From: Andrew Wood
Sent: 09 December 2019 11:34
To: Planning Scanning
Subject: FW: WA/7/19/RES - Lanes End, West Walberton Lane - Extension of time request

WA/7/19/RES - Lanes End, West Walberton Lane - Additional information request

Plot 4 and 5

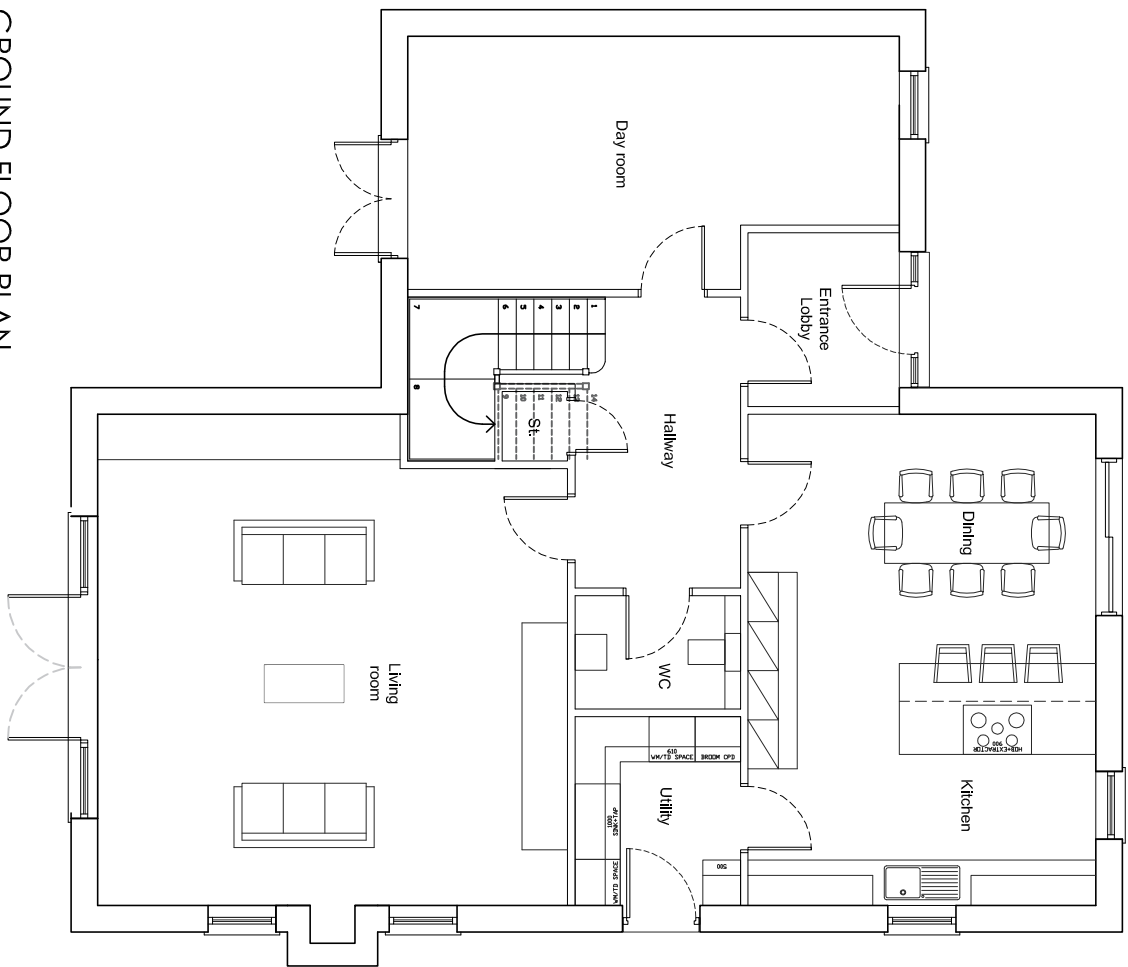
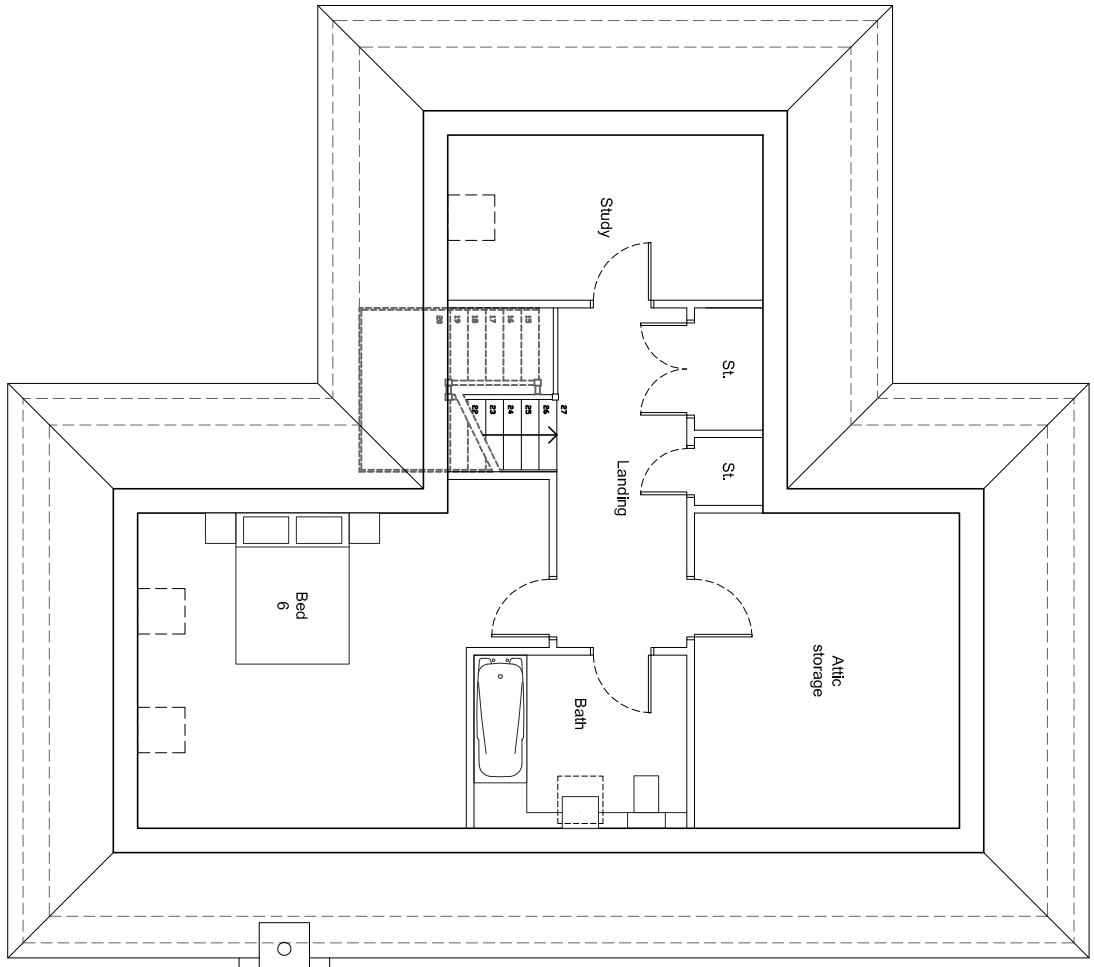
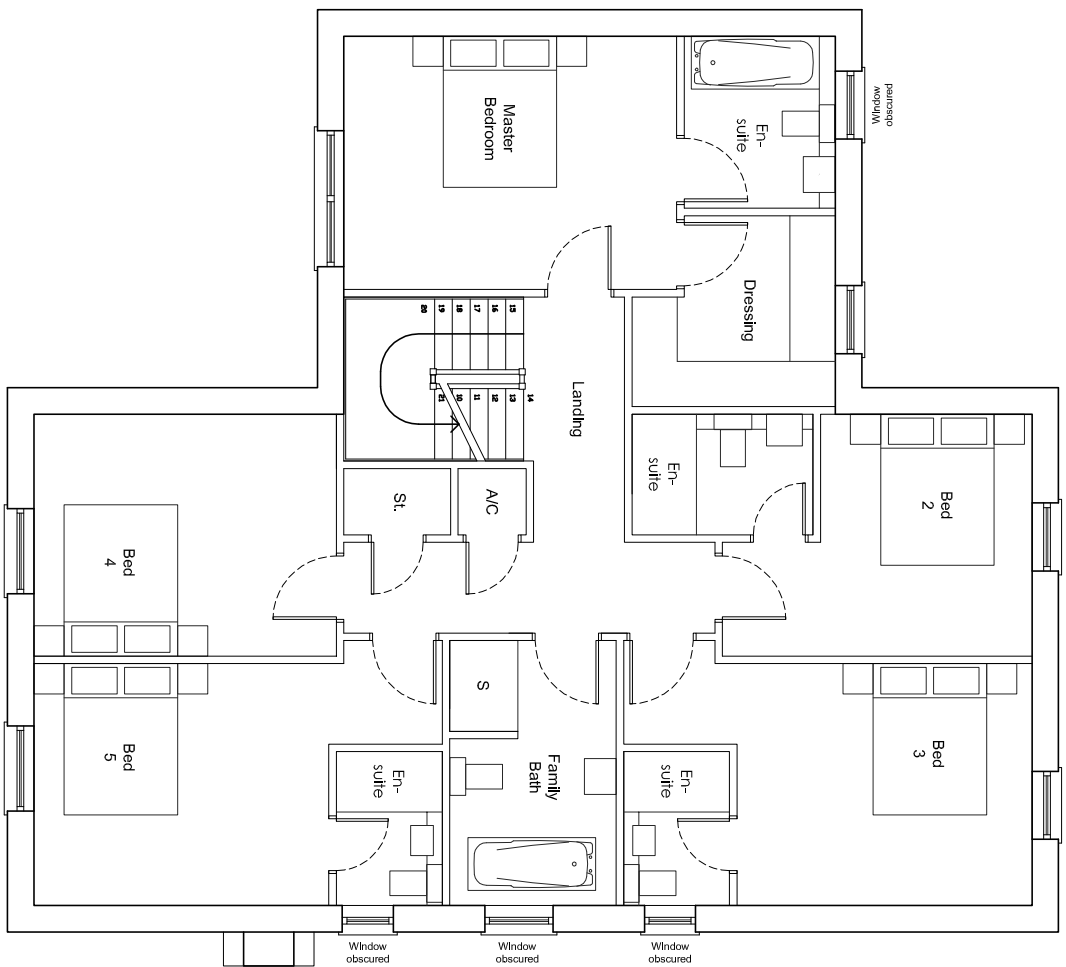
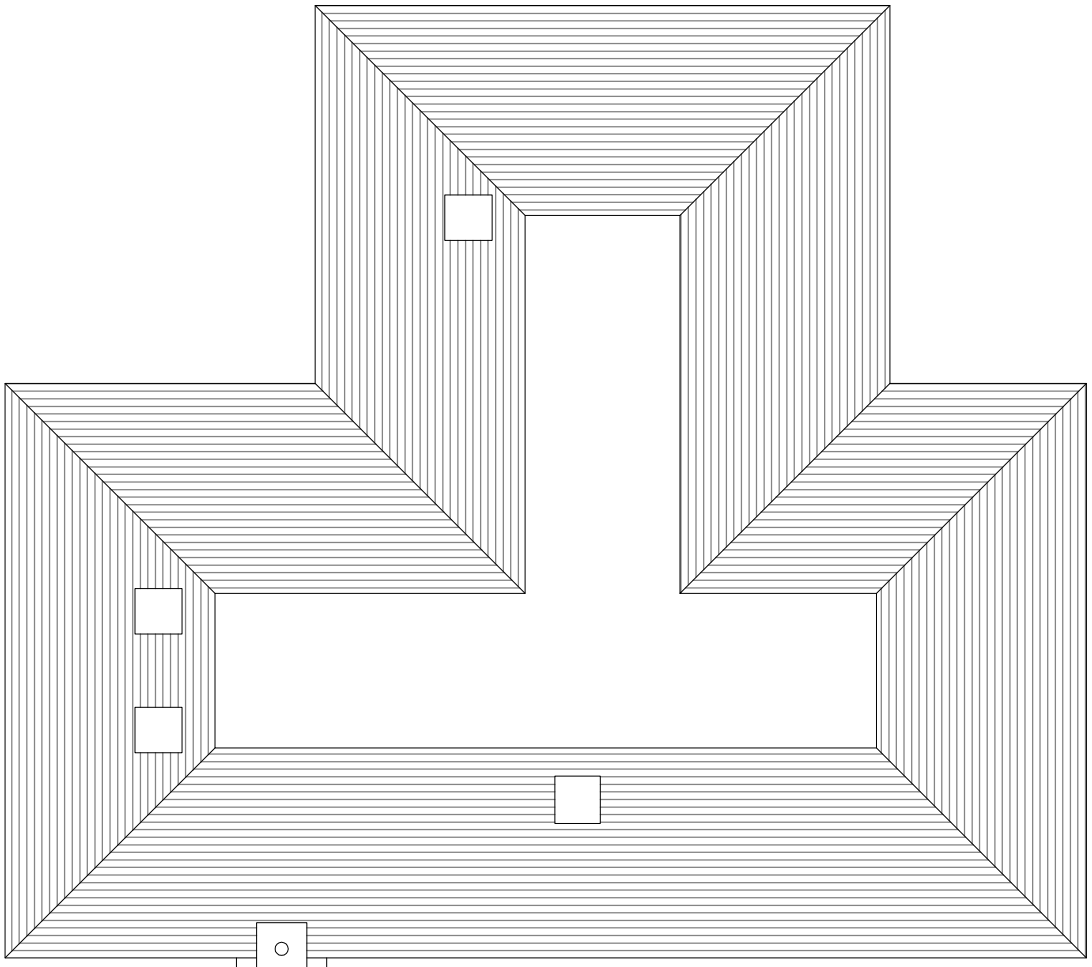
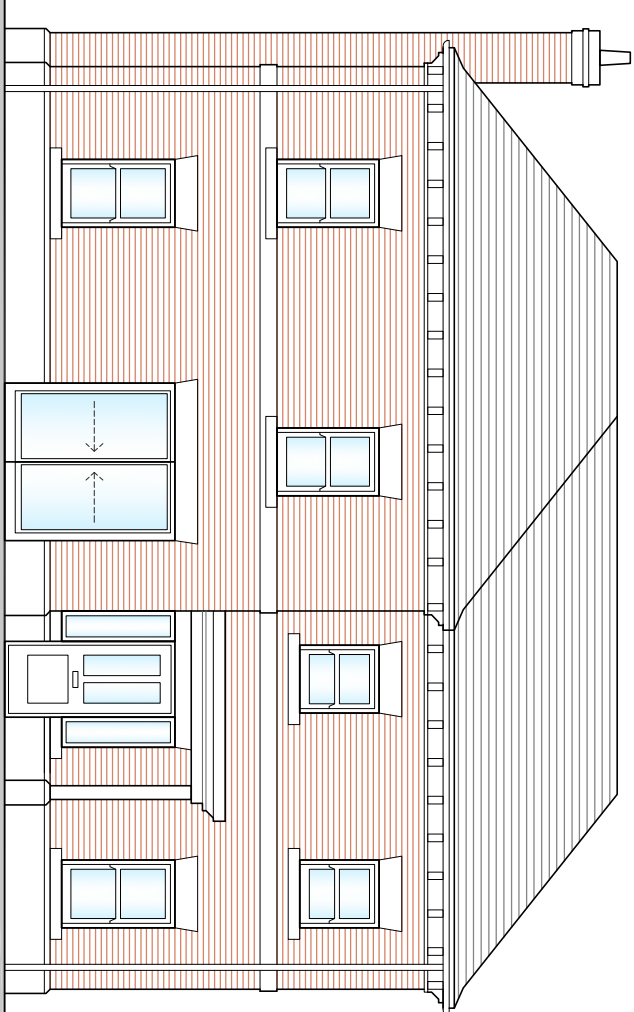
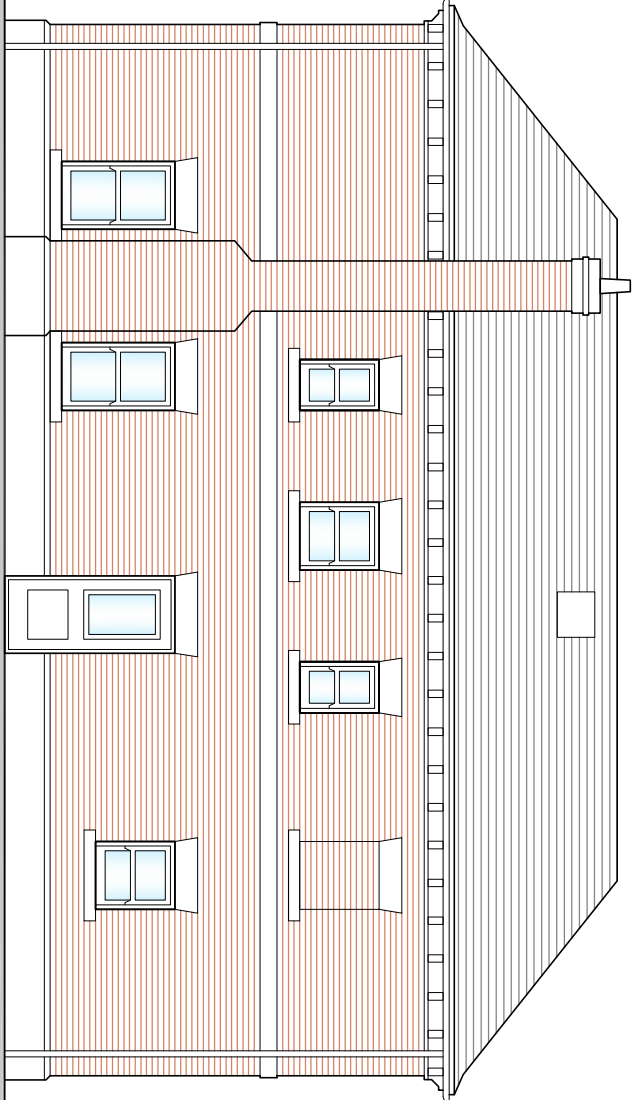
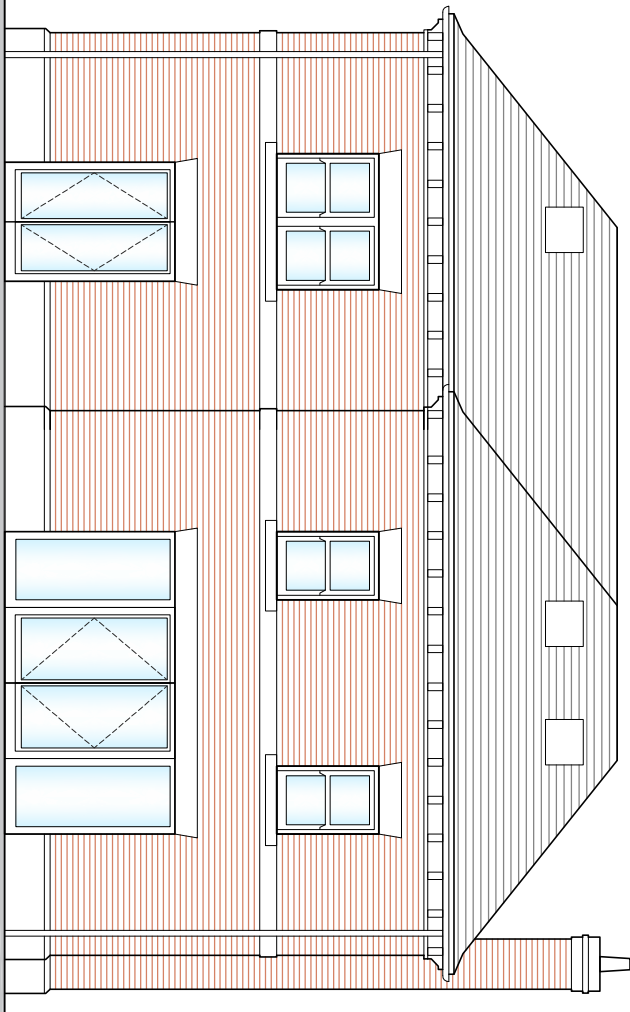
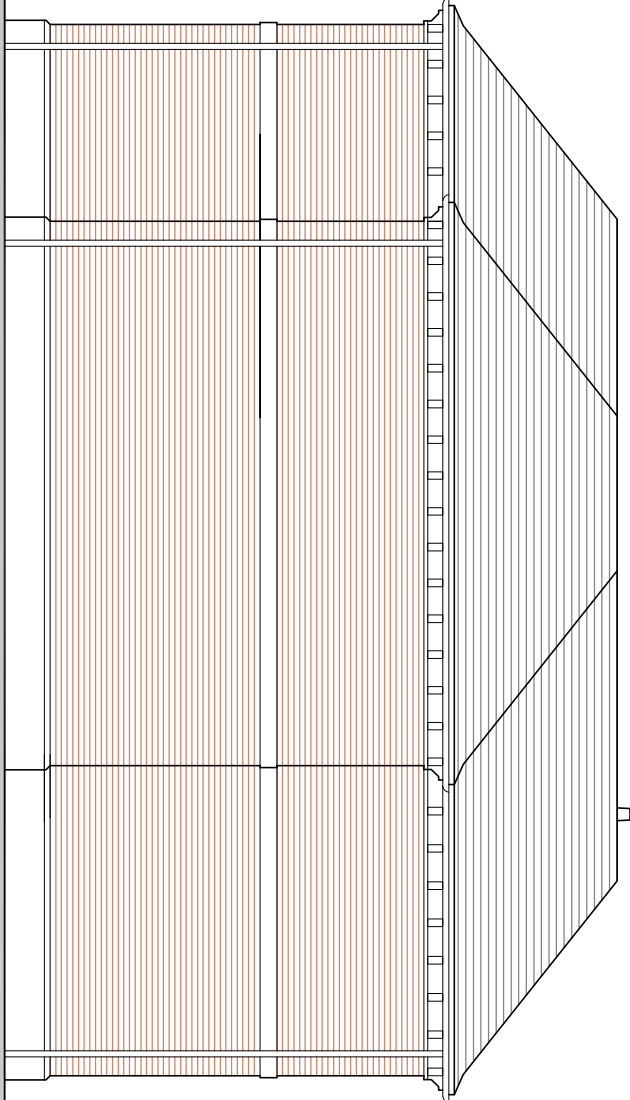
the issue with the rooms in the roof is that the appearance of the dwellings will be of a town house which is simply not appropriate in this location. I would strongly advise you to remove this element from the scheme. To avoid the risk of the development being viewed as 'out of character' in the area and contrary to policy D DM1 of the Arun Local Plan. I have discussed the matter with my line management team and everyone is of the same view in this case.

1. Amend the layout to ensure that a minimum of 9 metres exists on from blank gable end (or obscure glazed windows non opening below 1.7 metres in height) of nearest proposed house to gable end of 'Woodlands' which currently incorporates sole habitable room windows.
2. Remove second storey of houses/rooms in roof. 3 storey townhouses would not be acceptable in this location

2, we fail to see the merit in removing the room in the roof, this would have no impact on the height of the buildings and would result in empty lift spaces which would not allow for good use of space as per the NPPF. You will note from drawing 19-001-PL-03 all the dormers on houses 3-6 are in the south and therefore can not be seen from the front or any point outside the properties. Currently prosperities one and two have the dormers on the north but I would be happy to move these to the south so these are the same and none can be seen from Arundel road. I also would like to mention the design of white cottage next door that will have dormers in the roof and Richmond house which has velum windows in the roof. As previously mentioned the new ridge heights will be lower than the current house at Lanes end this can be seen in the scale drawings provided. If you could let me know if this is acceptable as if possible to avoid I would prefer not to have to appeal the reserved matters for this small item.
